ADC PARKS & GREENSPACE ARBORICULTURE

PLANNING APPLICATION: BE/60/15/PL

ADDRESS: Demolition of existing dwelling & erection of 8 No. three bedroom dwellings with new access & car parking.

BRIEF DESCRIPTION: 21 Bucksham Avenue Bersted PO21 5DT

APPENDIX 1: TREE PROTECTION PLAN

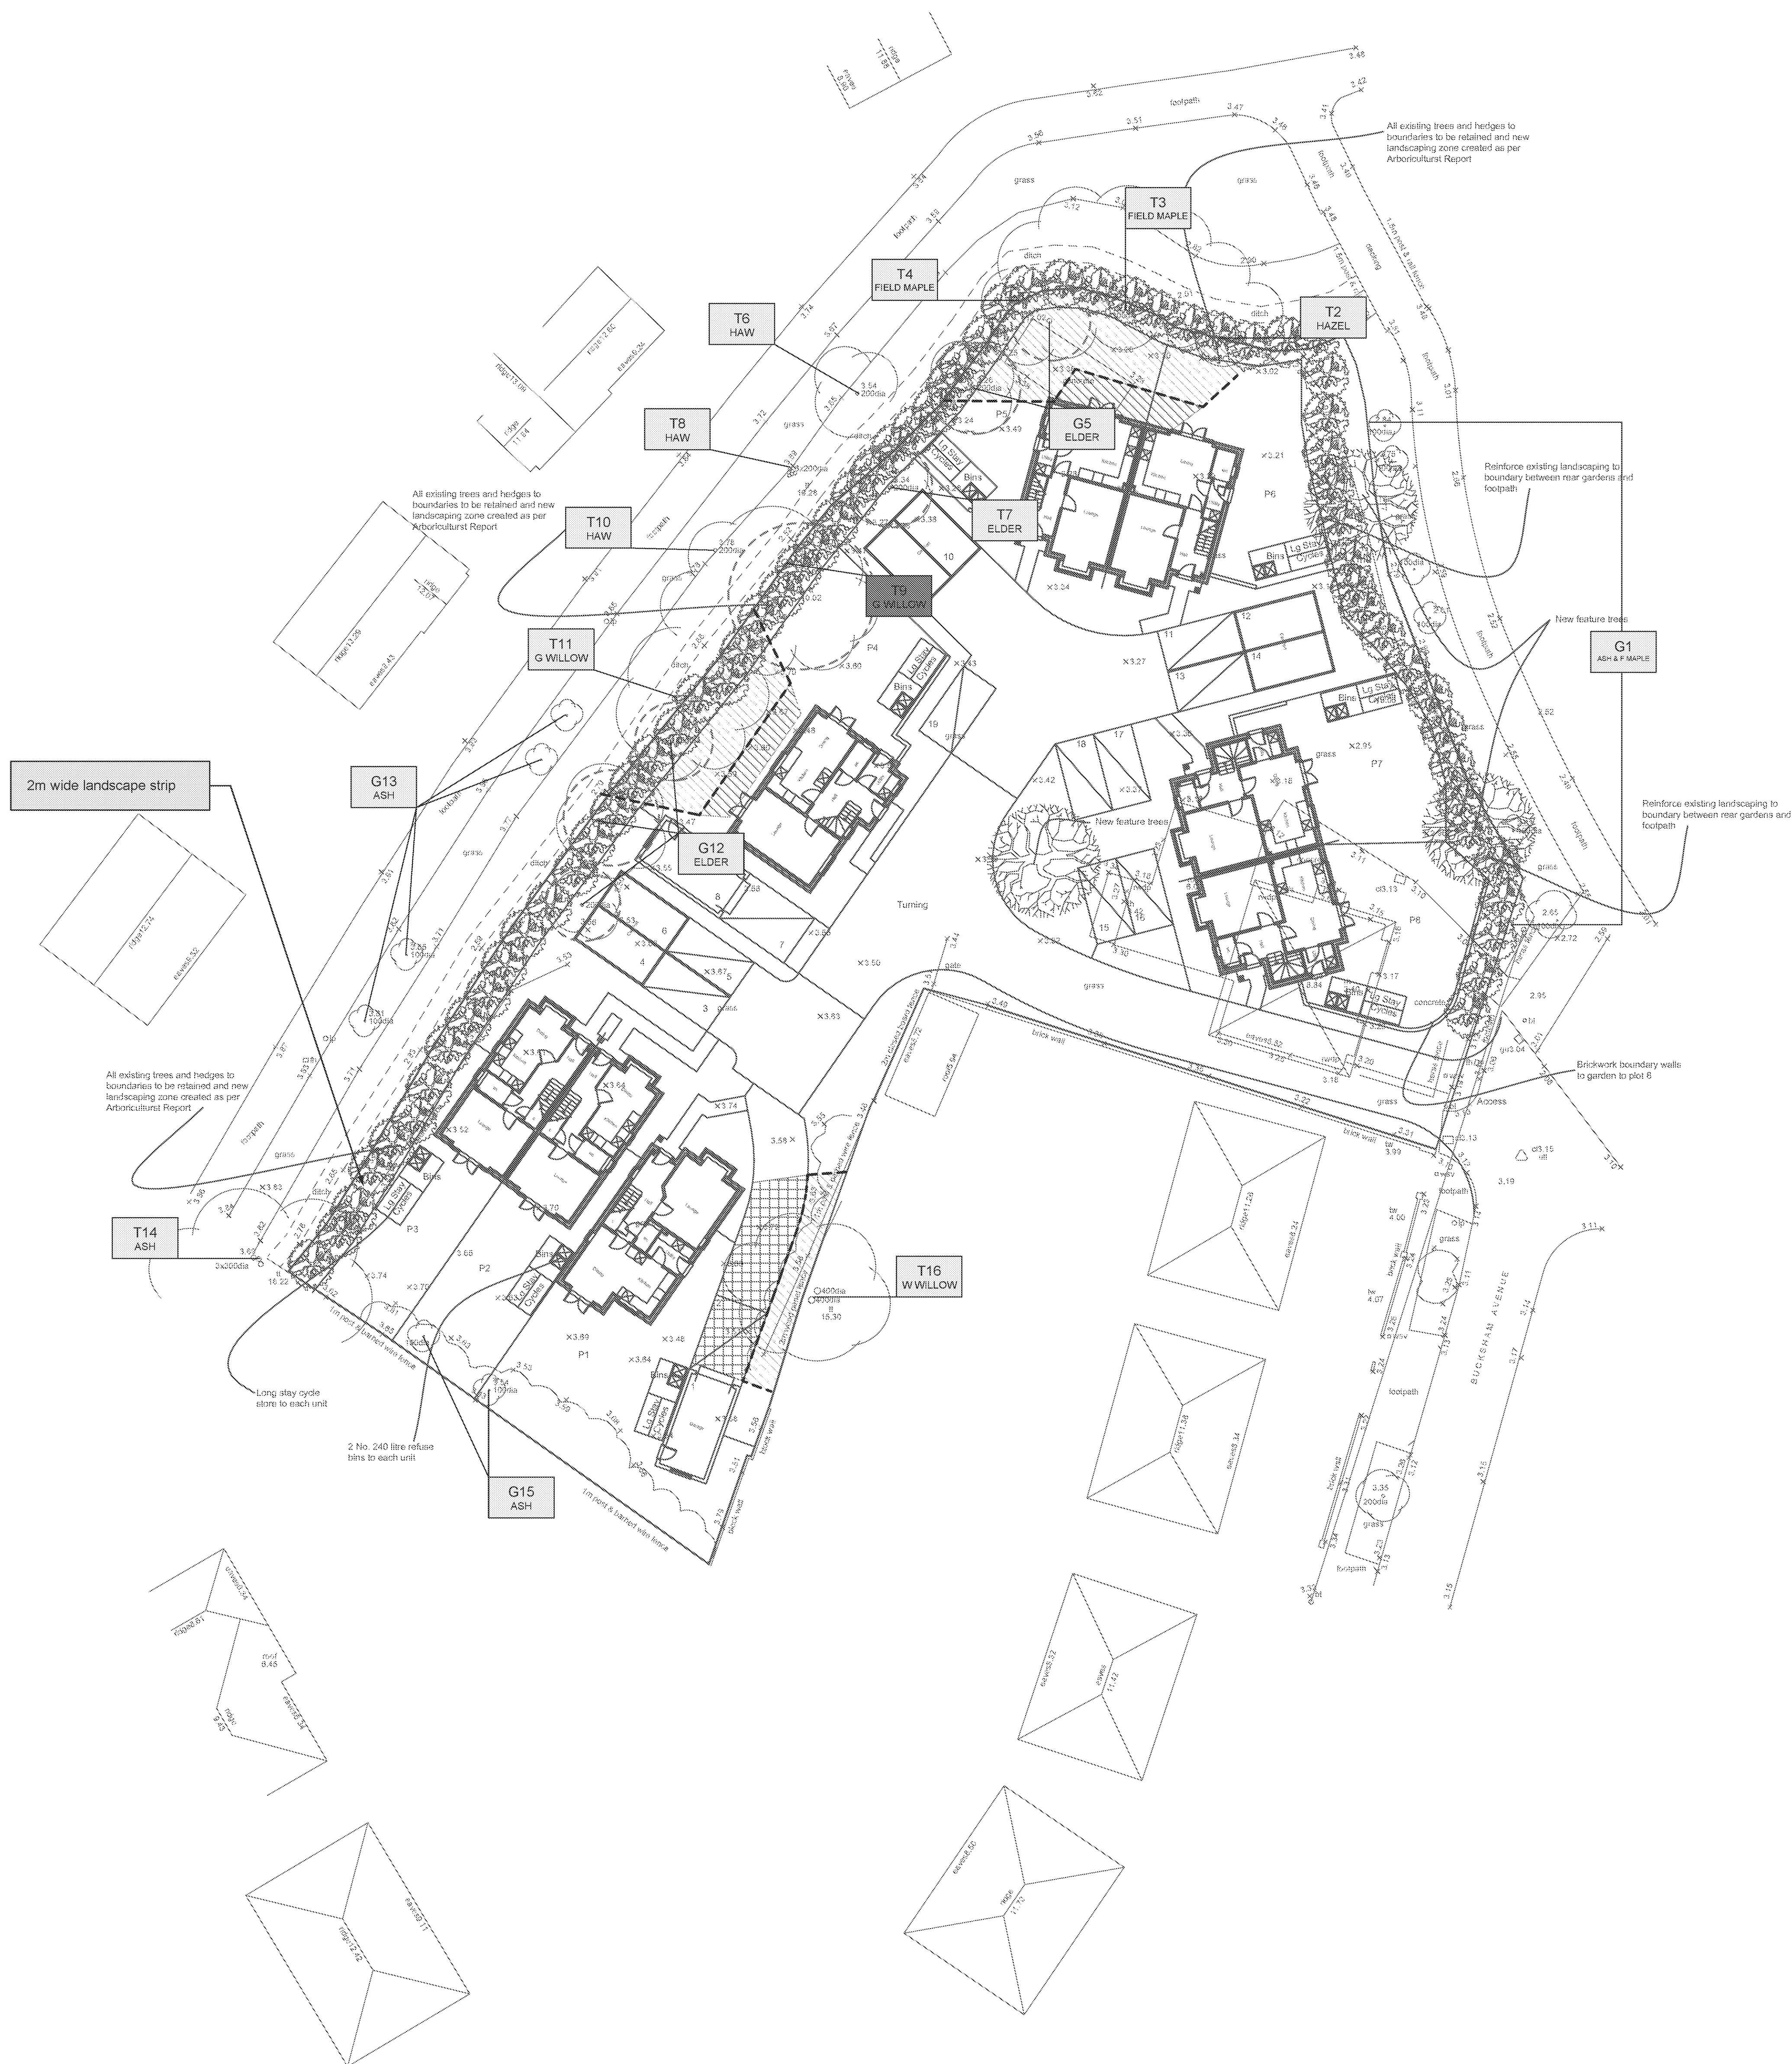
- I do have a concern about the proximity of the proposed development to **T11** (an early mature specimen). Although the development of housing unit **P4** has mitigation in place for intrusion into the RPA of **T11**, the application has not allowed space for further physical development of **T11**.

- Although the applicant has met the standard as described by the BS 5837:2012, I do have reservations about the proximity of the proposed dwelling **P4**, and the proximity to **T11**. I would therefore object to the proposed application
- The following conditions are to be adhered to;

- A greater allowance is granted for **T11** future growth and development, by relocating the footprint of **P4**.
- Suitable ground protection (membranes) within the exposed RPA areas must be established for **T3** and **T11**, before the construction/demolition process commences.
- Low invasive surfacing is used for the exposed area of the RPA of **T16**, and is installed prior to the construction/demolition process beginning.
